3d Community Church

659 Graham Rd Sanford, NC

12/18/25

Building Inspector

LIFE SAFETY PLAN

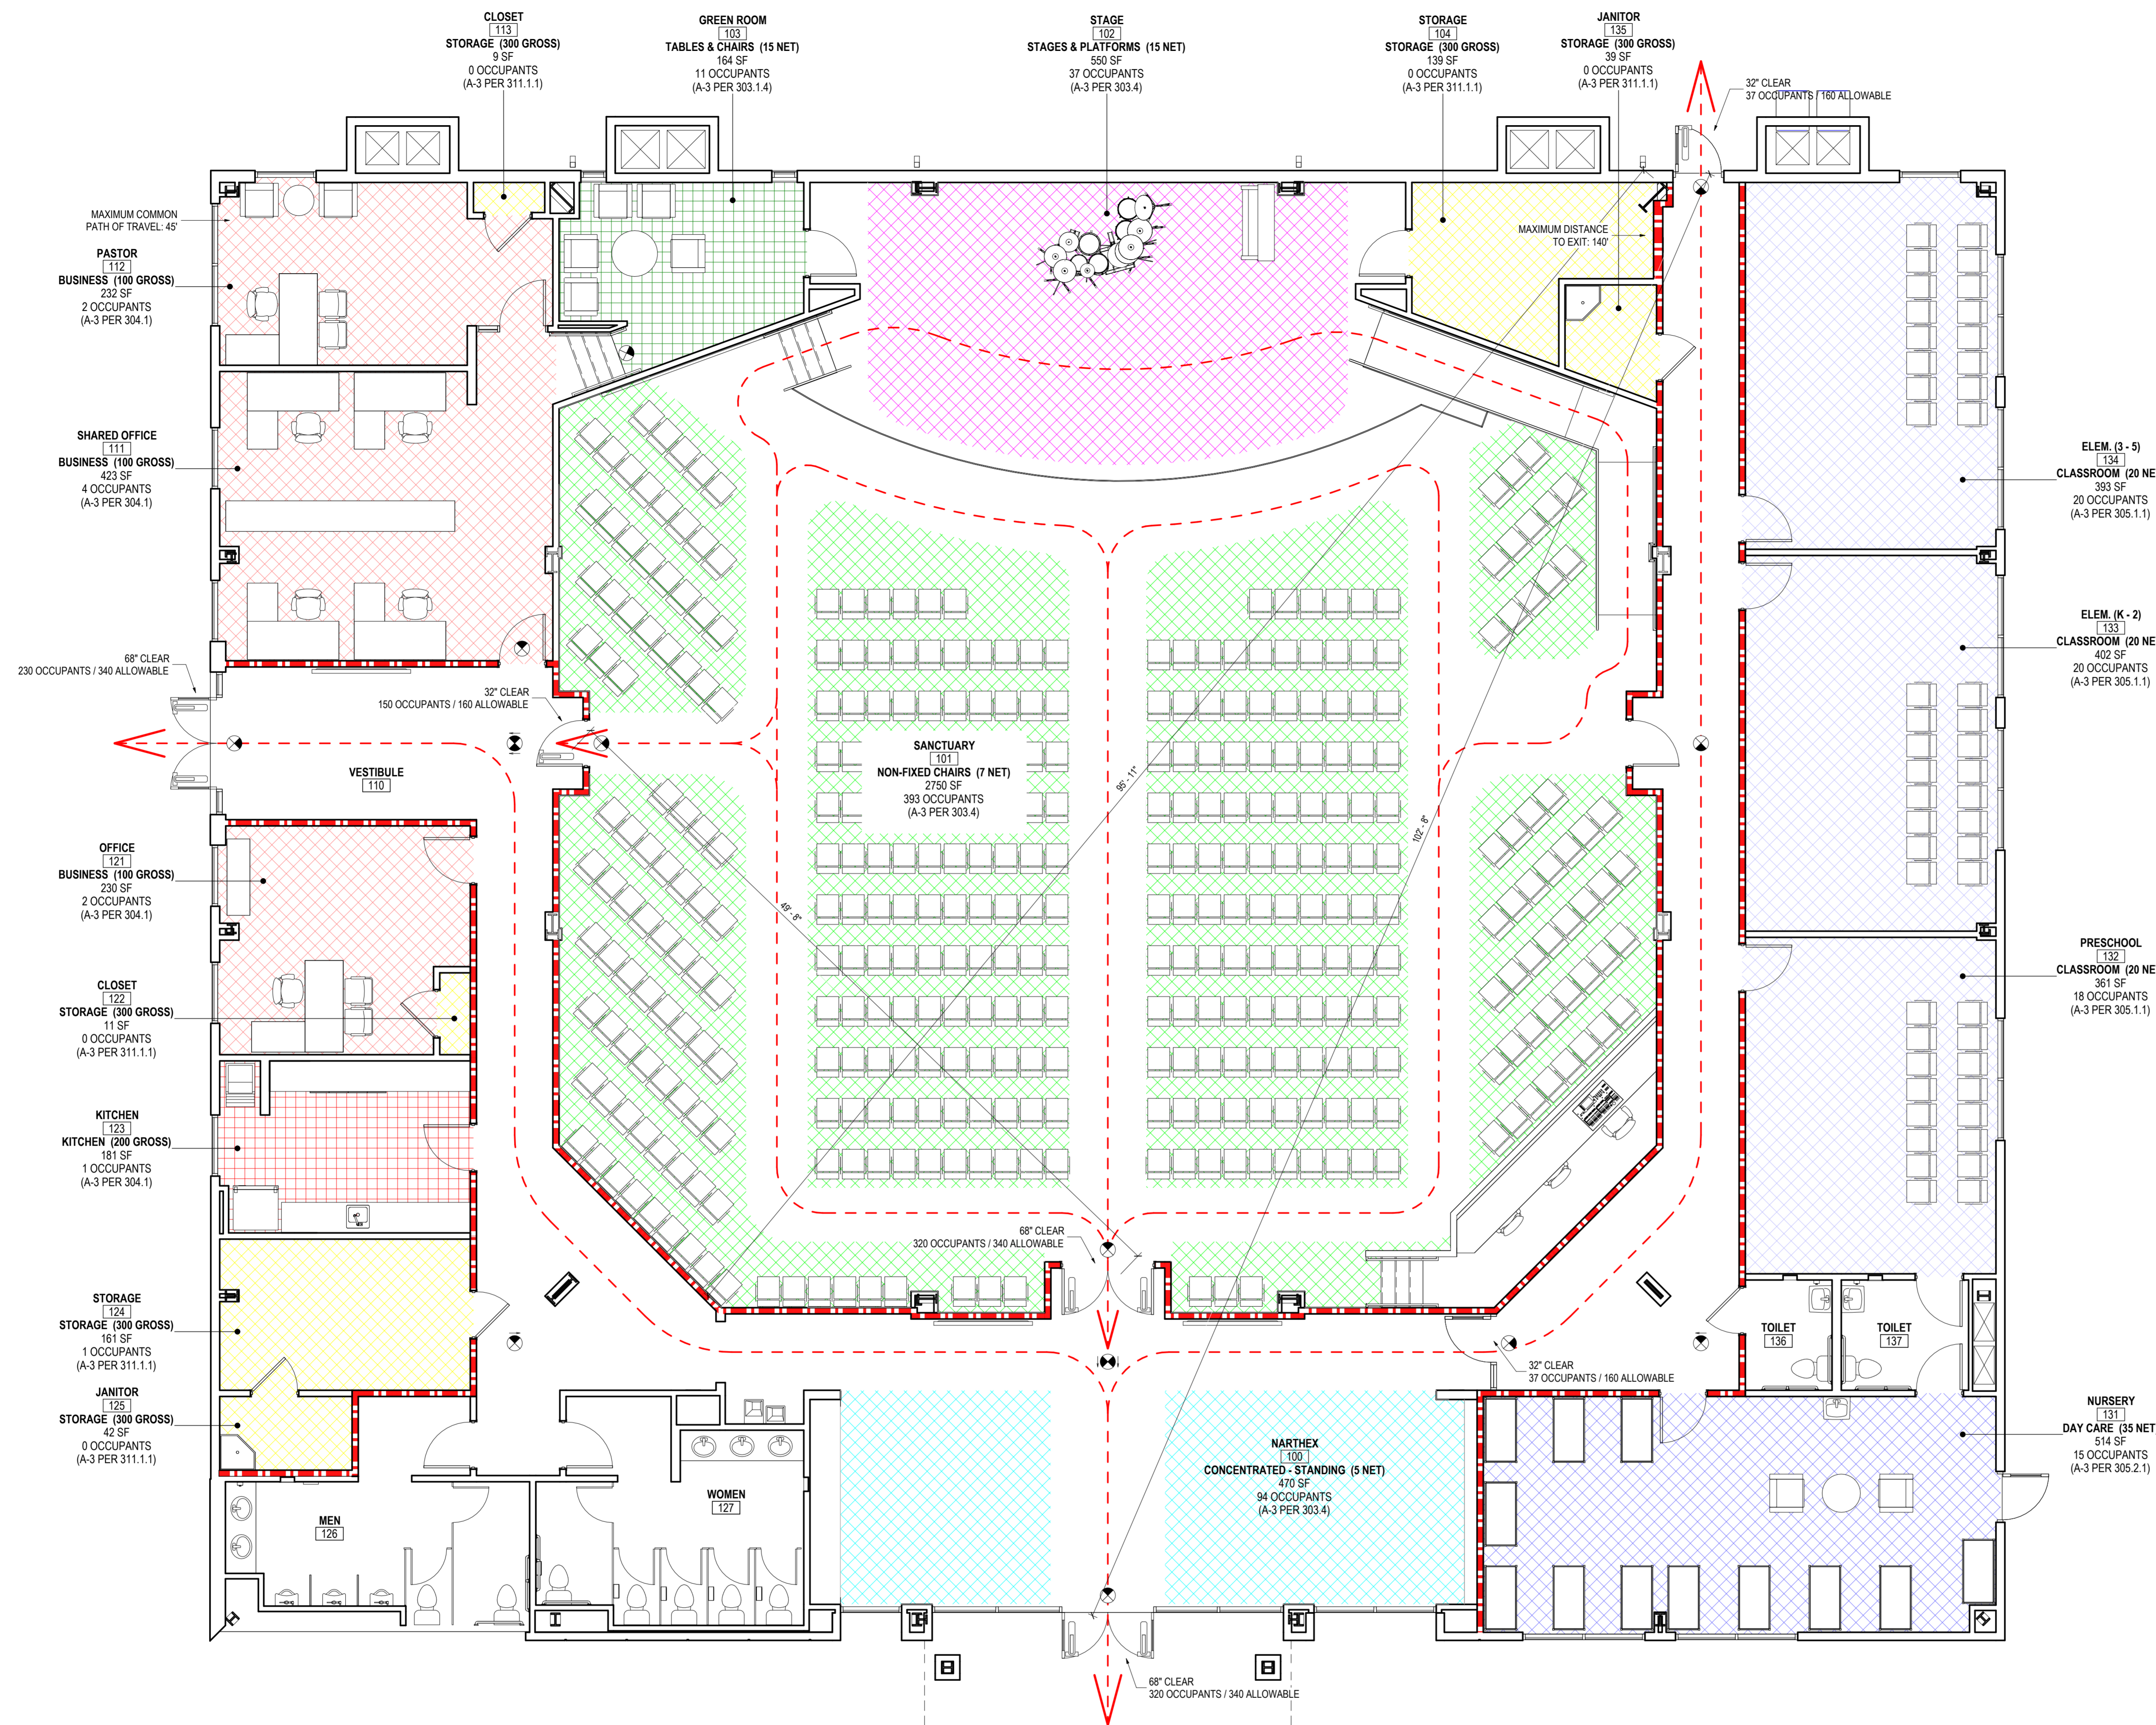
General contractor shall extend the one and two-hour fire rated wall framing and sheetrock tight to the roof insulation/tarp system. Apply fire caulk at the top of sheetrock. Allow deflection at the roof structure. — Follow UL Designs UL419 and V449.

Provide top of wall condition at rated walls indicated in red and orange below.

Hilti Detail CJ-D-0008 is good for 1, 2 and 3 layers of Sheetrock as well.

This includes for the 2 hour fire wall one layer on one side and three layers at the other side.
